Recommendation Report for Planning Permission for Works or Extension to a Dwelling

REF NO: PO/15/21/HH

LOCATION: 2 Arundel Road
Poling
BN18 9PW

PROPOSAL: Erection of two storey side extension following the demolition of existing single storey side extension and front porch.

DRAWING TITLE
PROPOSED GROUND FLOOR PLAN

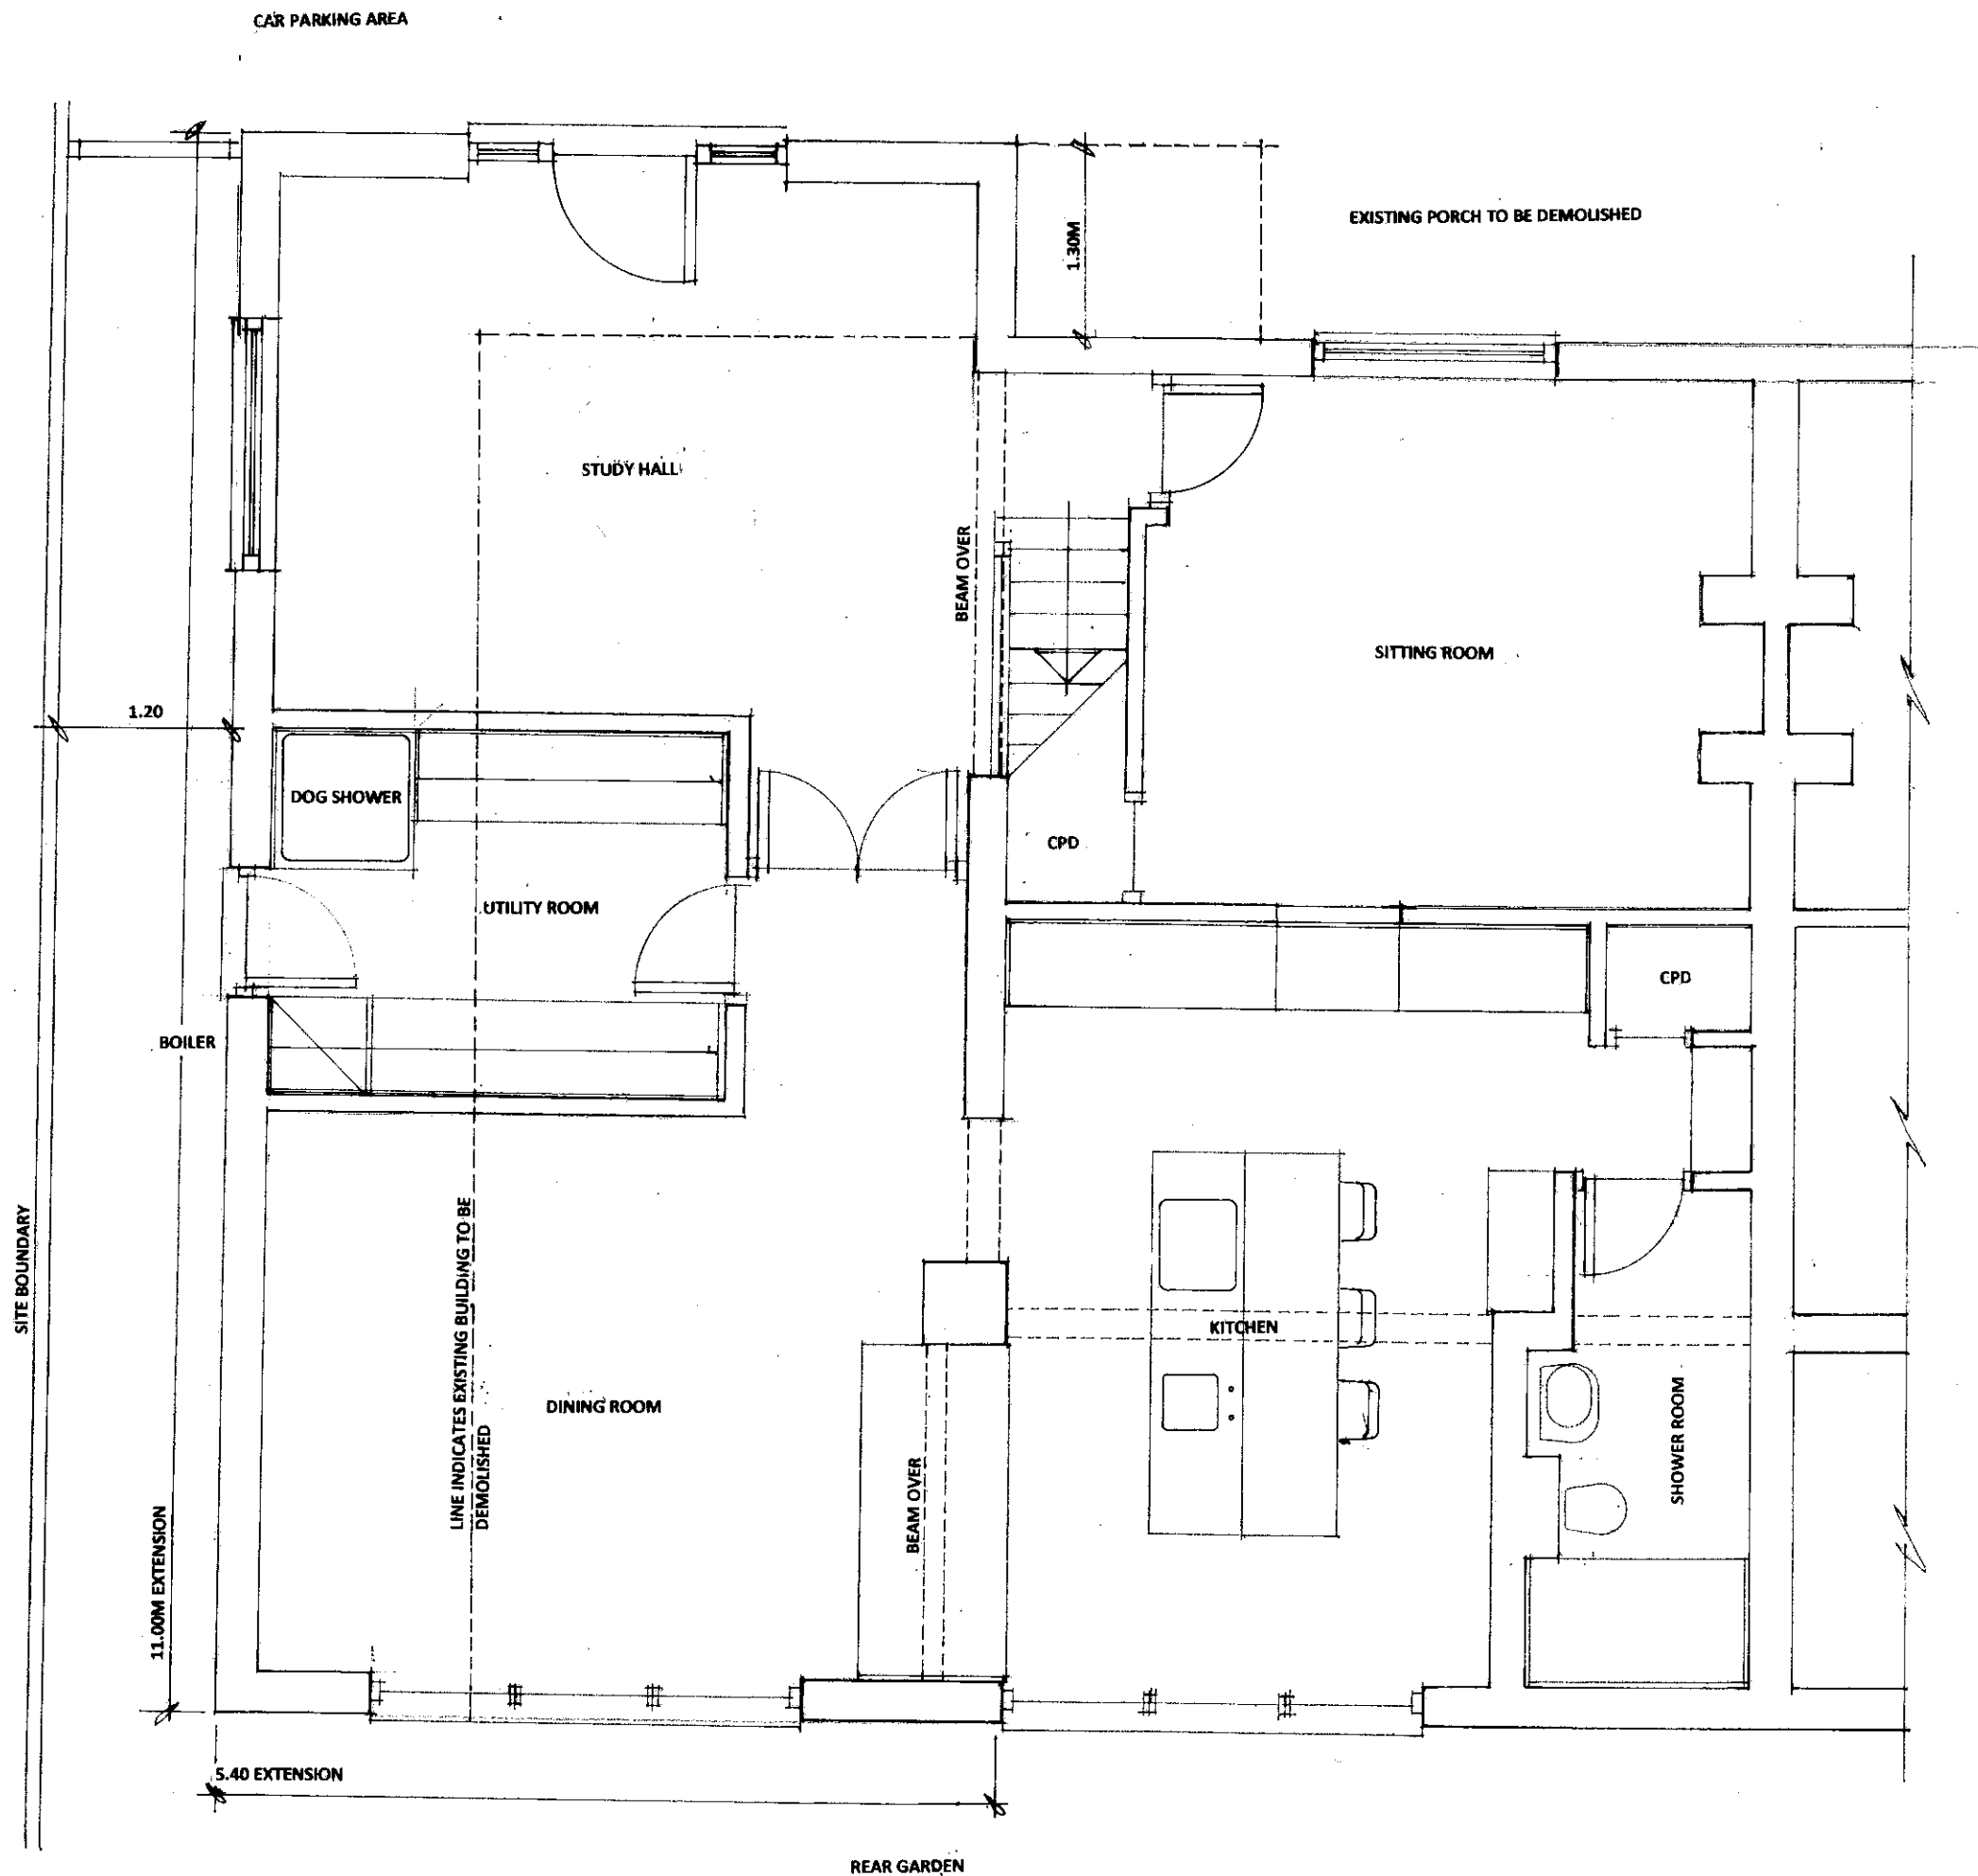
The extension features a window and new front access door with side lights to the front, two windows and a door to the side, and a set of windows and doors to the rear. It additionally features the removal of the existing front door and installation of new first floor window to the original front elevation. The features to the front and rear do not overlook or overshadow any neighbouring properties and have minimal impact on residential amenity. The windows and door to the side overlooks the east wall of No.3 Arundel Road, which exhibits a window on both the ground and first floor. Although directly facing, the privacy of the neighbouring property is respected, with the first floor window of the proposal being glazed. Visibility of the property is therefore restricted, and overlooking from the ground floor will be limited by the fence that sits on the boundary. Considering this, along with their scale, these features will not have a detrimental impact on the neighbouring property and will not result in adverse overlooking, overbearing or overshadowing.

DRAWING TITLE
PROPOSED ELEVATIONS

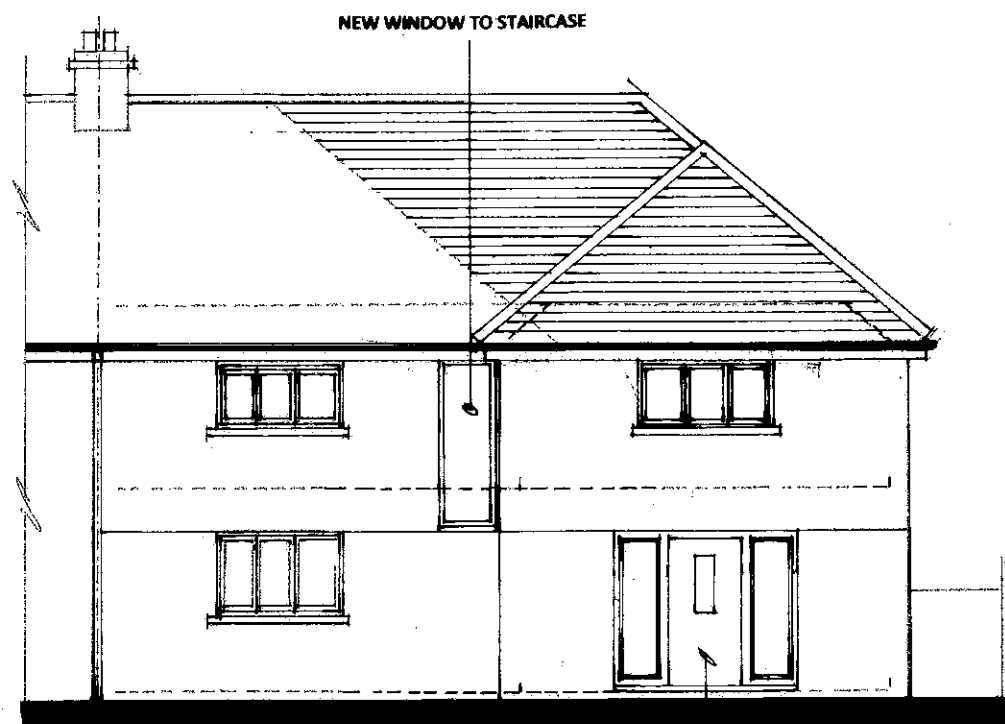
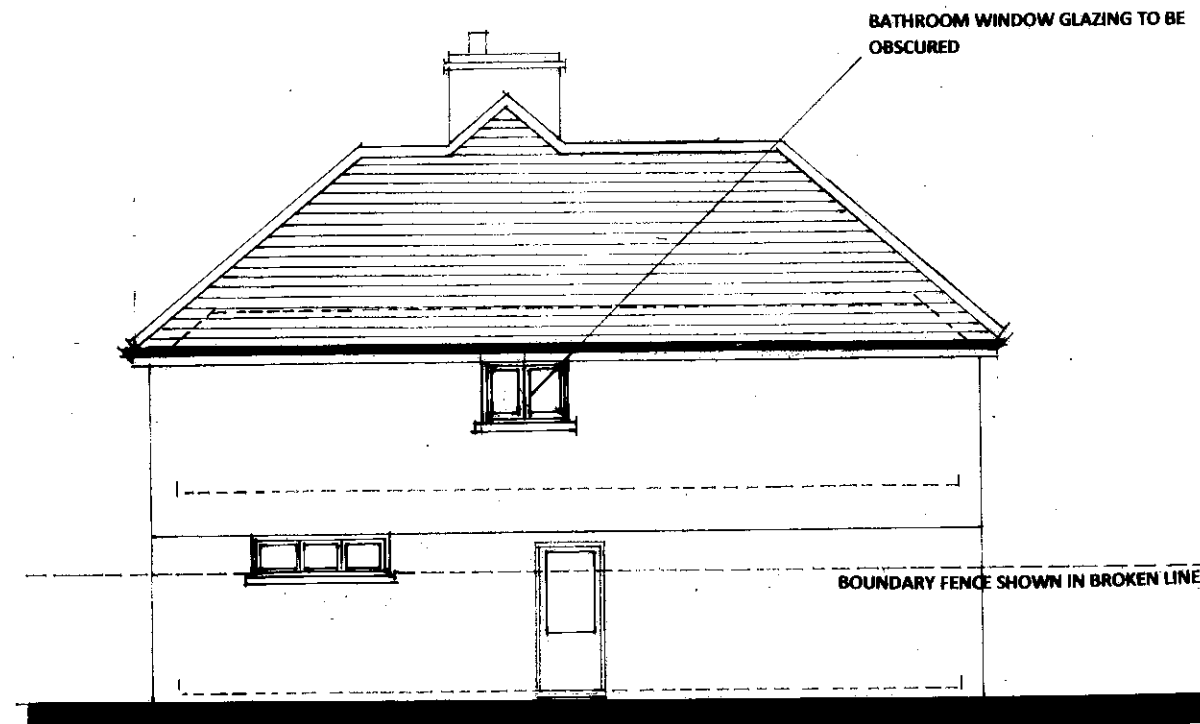
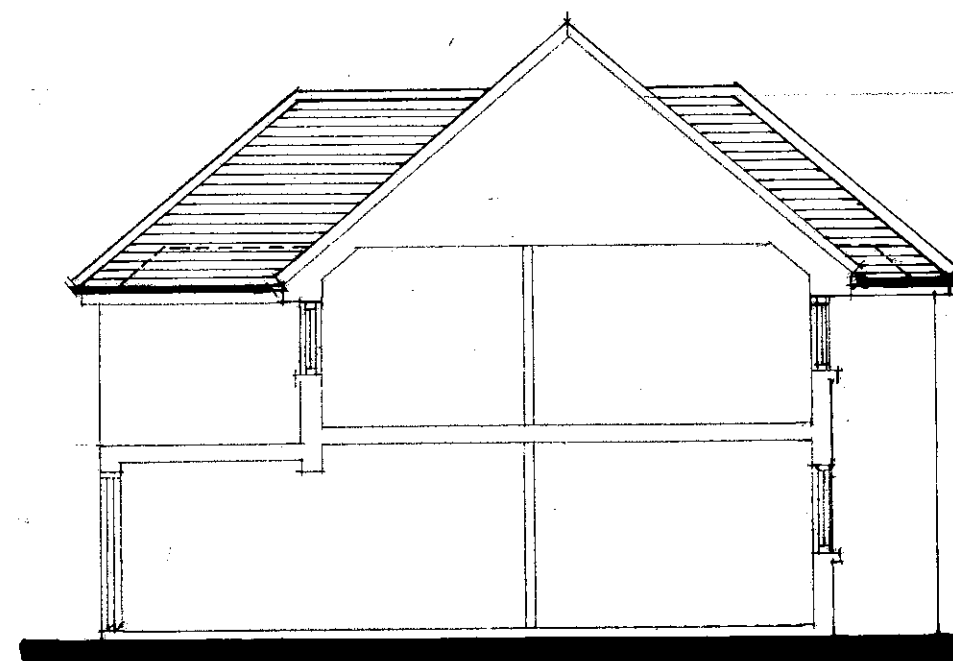
The extension is two storey, with a depth of 11m and width of 5.4m. It incorporates a hip roof, following the same pitch and style as of the existing. The proposal maintains the established building lines, but does extend from the footings of the existing extension by around 2m to the side and 1.3m to the front, to line up with the current front porch (set to be demolished). This causes a protrusion to the front elevation and alters the building line of the property. Arundel Road is comprised mainly of symmetrical pairs of 1930s-1950s semi-detached houses, the majority of which follow similar design styles and appearances. A number of the properties feature two storey extensions to the side, similar to the works proposed in this application. These vary in size, but generally do not protrude past the front elevation of the original building. Due to its protrusion, the proposal may appear unbalanced with its attached neighbour. However, as the extension itself appears relatively subservient to the existing, in terms of roof and elevational design, and is well integrated, the impact upon the appearance and character of the two properties will not be unduly harmful. The materials used will match that of the existing, helping to ensure the proposal has no adverse harm on visual amenity. Taking into account the existing works made to neighbouring properties, in the context of its surroundings, the proposal does not detrimentally impact the composition or rhythm of the street scene and is generally in keeping with the character of the area.

The proposal is two storey, and extends to the side and front of the property. The existing roof height of 8m is retained, with extended parts of the roof to the front and rear having a slightly lower height of 7.3m. The eaves match that of the original, at a height of around 4.7m. The building retains a distance of 7m to the front (north), 21m to the rear (south) and 1.2m to the side (west) boundary. It is a large extension,

and is at risk of overshadowing neighbouring properties to the west. However, by retaining a distance of 1.2m and meeting the 70 degree rule set by the Design Guide for side extensions, the proposal is considered to be in accord with D DM4 and will not result in unacceptable overbearing or overshadowing.

Reason: To comply with Section 91 of the Town and Country Planning Act 1990 (as amended).
- 2 The development hereby approved shall be carried out in accordance with the following approved plans:
 - Location and Block Plan 12104.01
 - Existing Ground and First Floor Plans 12104.02, 12104.03
 - Existing Elevations 12104.04
 - Proposed Ground and First Floor Plans 12104.05B, 12104.06B
 - Proposed Elevations 12104.07B
Reason: For the avoidance of doubt and in the interests of amenity and the environment in accordance with policy D DM1 of the Arun Local Plan.
- 3 The bathroom window on the west elevation of the building shall be glazed with obscured glass.
